A1 Birtley to Coal House

Scheme Number: TR010031

Late Consultation Response from the Environment Agency

Planning Inspectorate Scheme Reference	TR010031
Application Document Reference	EXA/D5/003
Author:	A1 Birtley to Coal House Project Team, Highways England

Figure 4: Sketch of the proposed temporary works

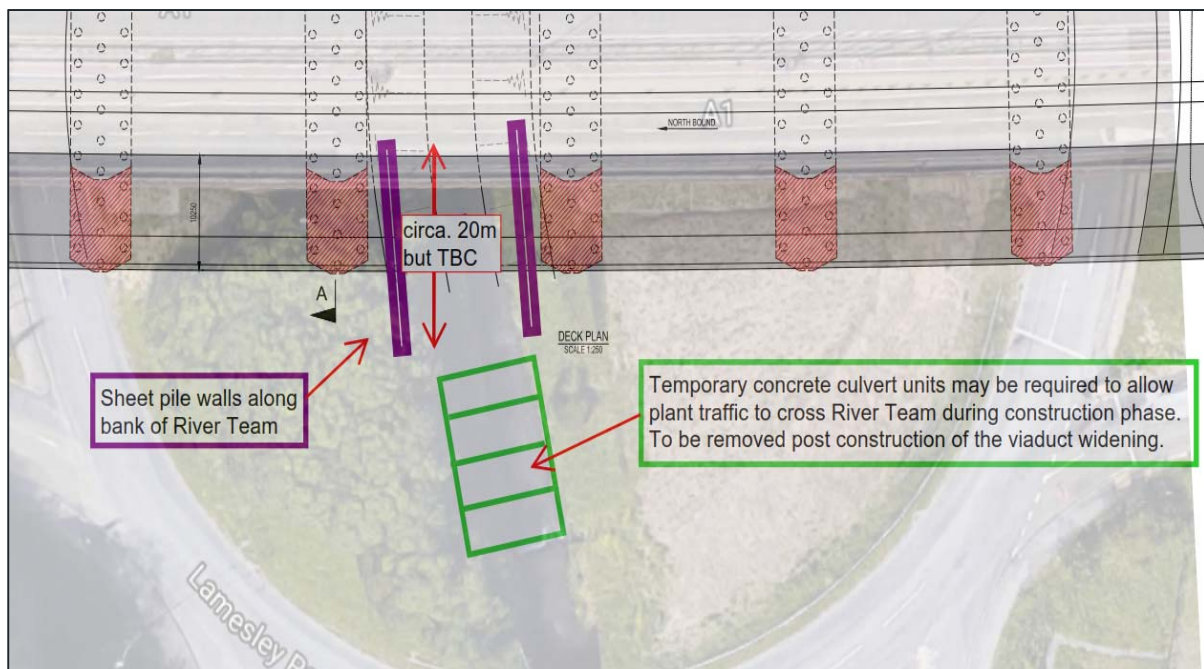
Ref	Consultee	Matter Raised	Applicant's response
		<p>the option will impact on our gauging station will need to be submitted. We are currently waiting for further information from the Applicant regarding this matter. Presently, we do not know what the temporary works are and how this will impact on flood risk and the gauging station.</p>	
		<p><u>Additional land Option</u> The proposed land take and stockpiling needs careful flood risk consideration just like the two other options we have reviewed. The reporting does not provide sufficient flood risk information to satisfy us that there is no increase in flood risk as result of these works and/or temporary works. This option should be modelled and/or a technical note needs to be submitted to explain why Applicant considers that flood risk modelling is not required for this option.</p>	<p>In terms of flood risk for the Additional Land the Applicant would like to draw the Environment Agency's attention to Figure 1.1 Scheme Location Plan within Appendix E of the Environmental Statement Addendum – Additional Land [REP4-058] which is reproduced in Figure 1 below. This shows that the Additional Land is not within either the fluvial (refer to Figure 2 below) or surface water (refer to Figure 3 below) flood plains (flood zone 3 or medium risk respectively) for the current day scenario, therefore, there is no requirement to consider the impacts of climate change given that the additional land is only required temporarily for the duration of construction.</p>

Figure 3-2 – Channel Design Concept - Plan

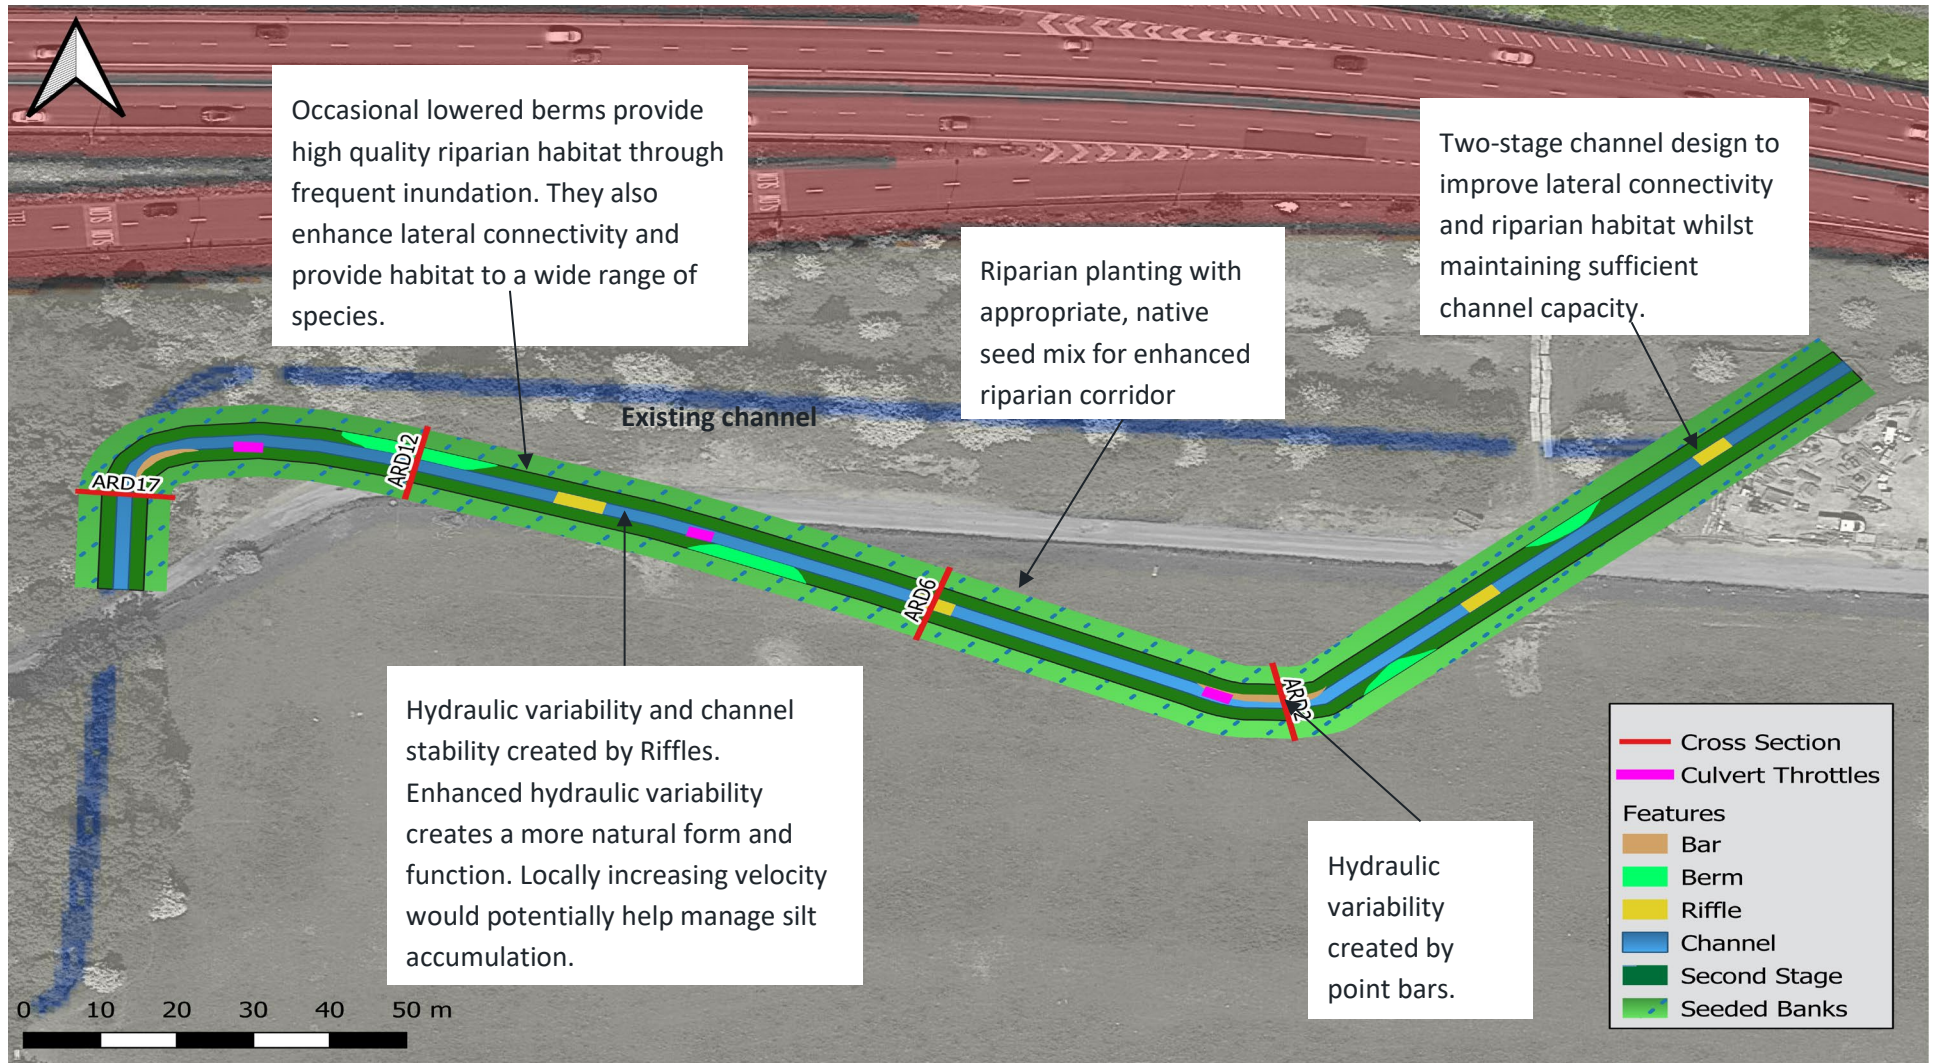
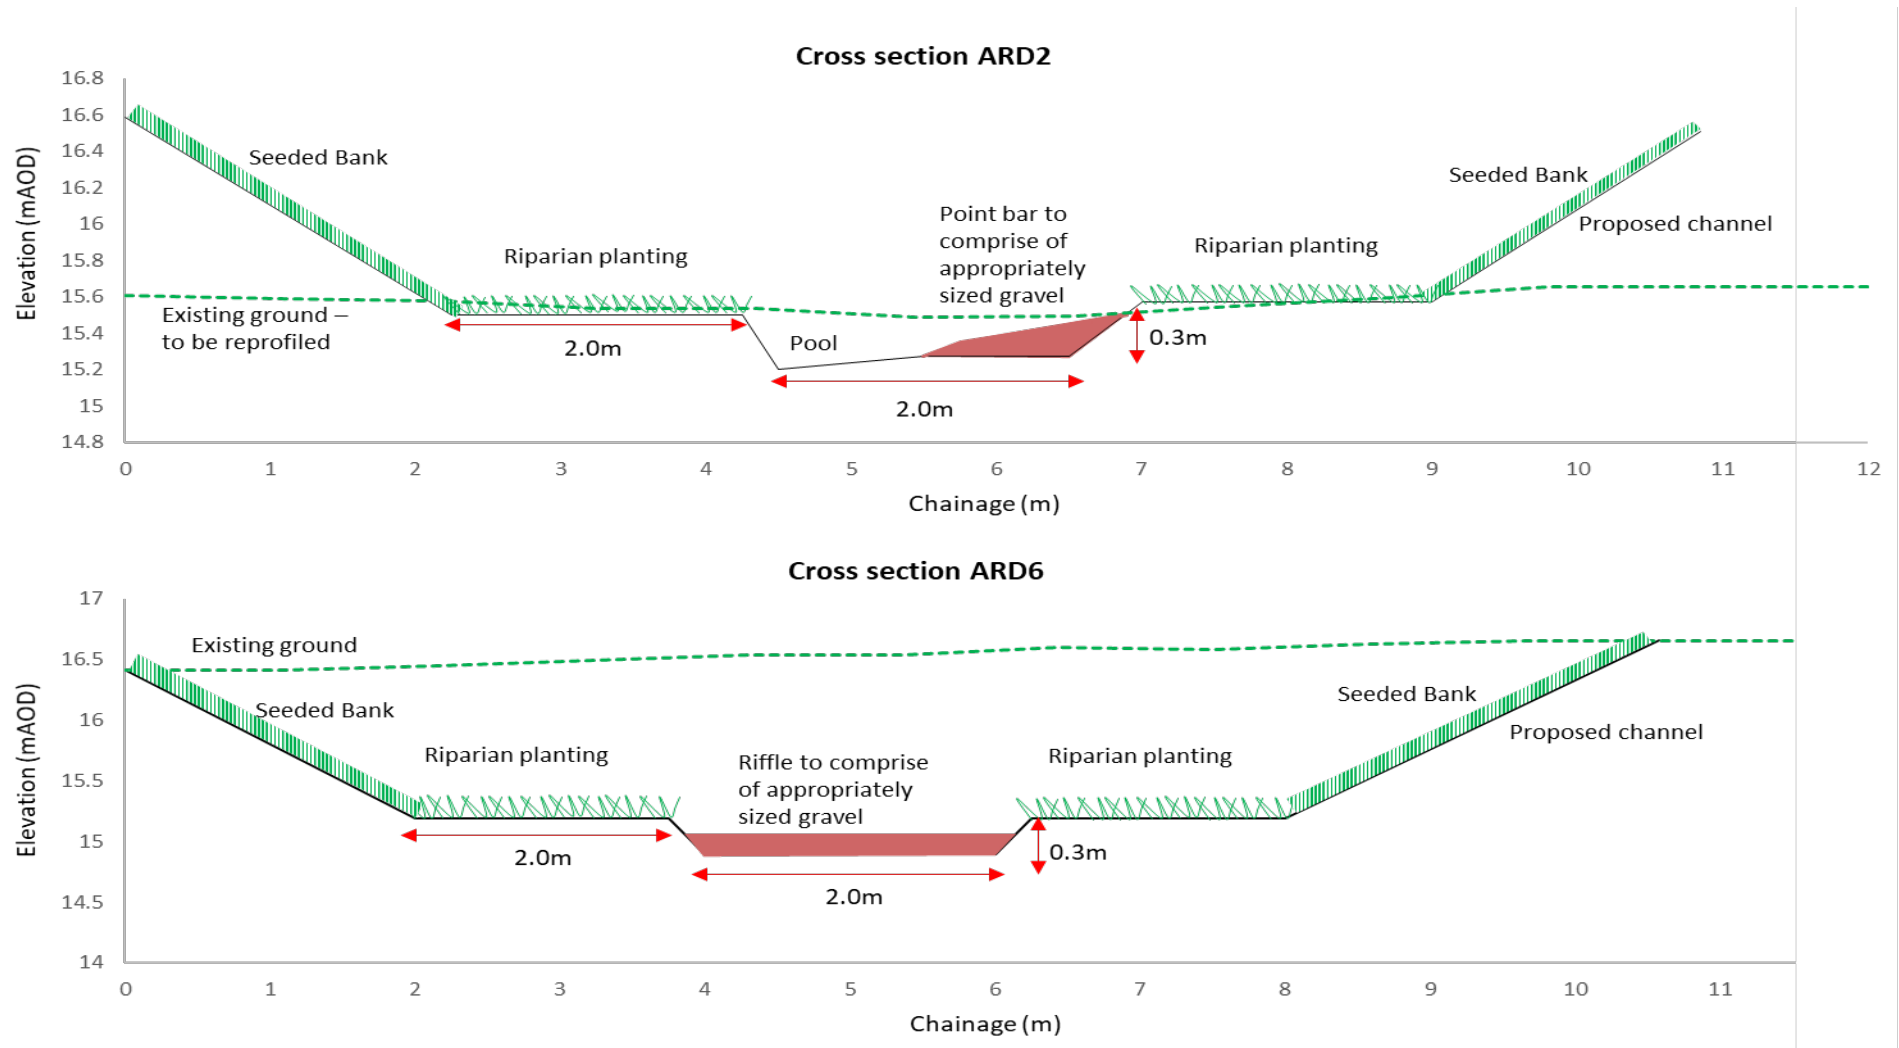
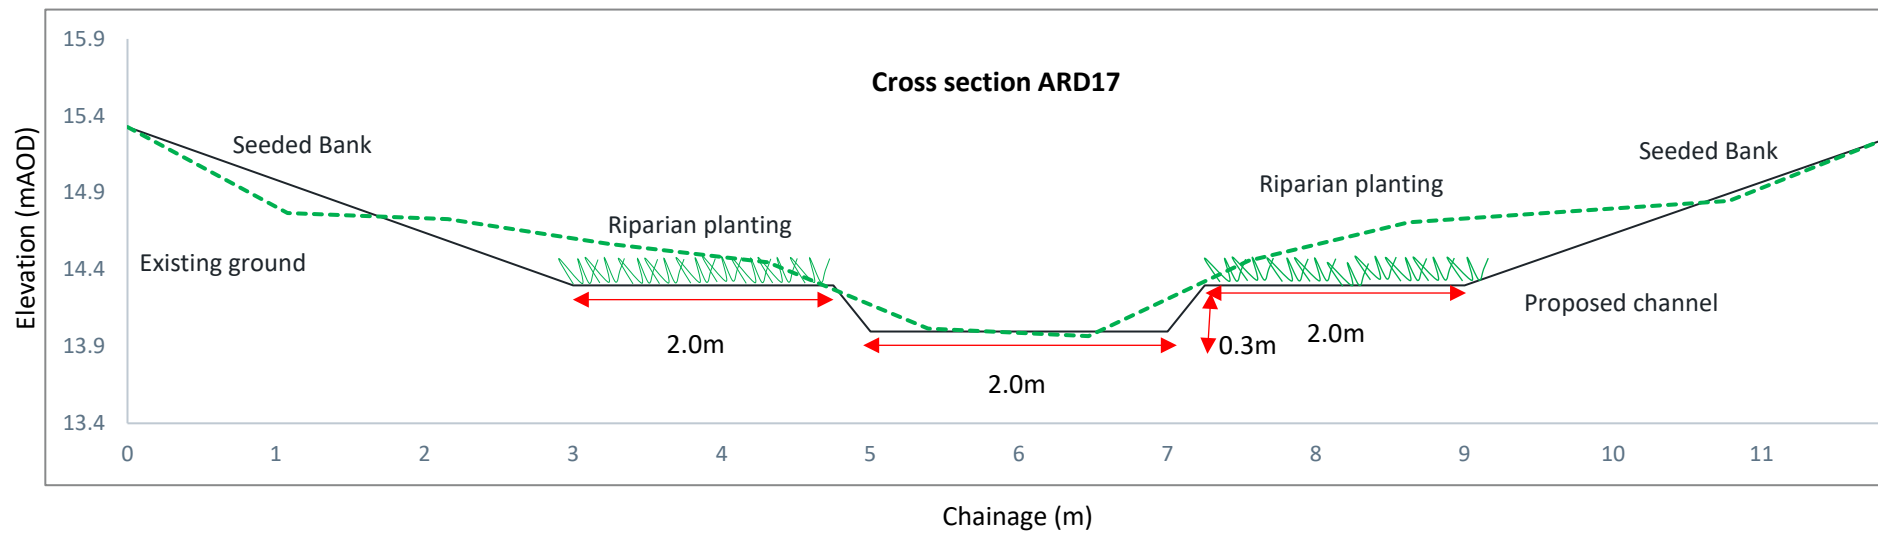
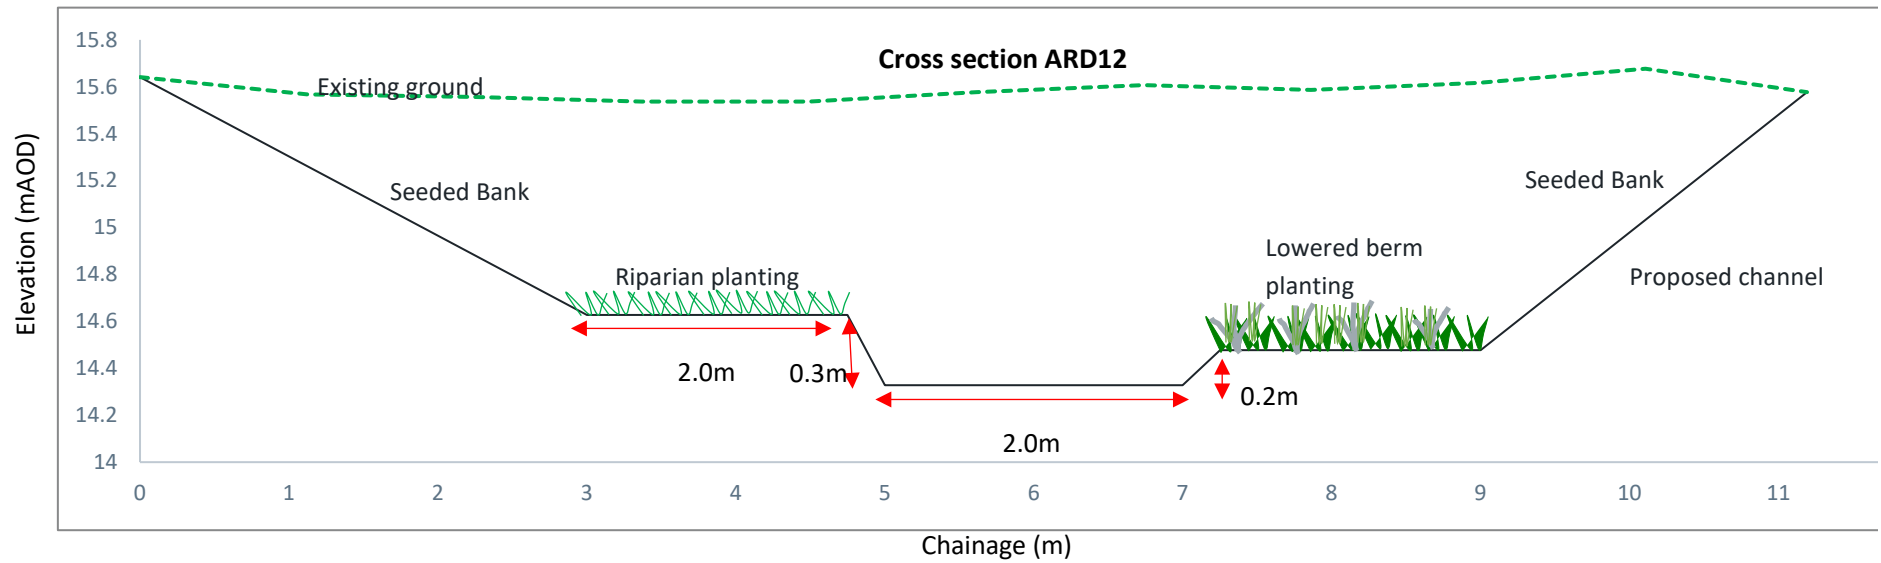
Ref	Consultee	Matter Raised	Applicant's response
		<p>viaduct option. Further WFD and biodiversity mitigation will be required to compensate and mitigate the WFD and biodiversity impacts of the three span bridge option. For example, there is space to significantly expand the area of the channel to include marginal zones and allow natural movement of the low flow channel within.</p>	<p>viaduct option. Allerdene three span option therefore cannot be considered a backward step when compared to the assessment previously provided and agreed with the Environment Agency, as detailed within the SoCG [REP4-026].</p> <p>There is, therefore, no requirement to provide any additional mitigation (in terms of WFD and biodiversity) for Allerdene three span option given that the channel relocation is essentially the same as that agreed for Allerdene embankment option and likewise there is no requirement to undertake a carbon calculation for the Allerdene Burn.</p>
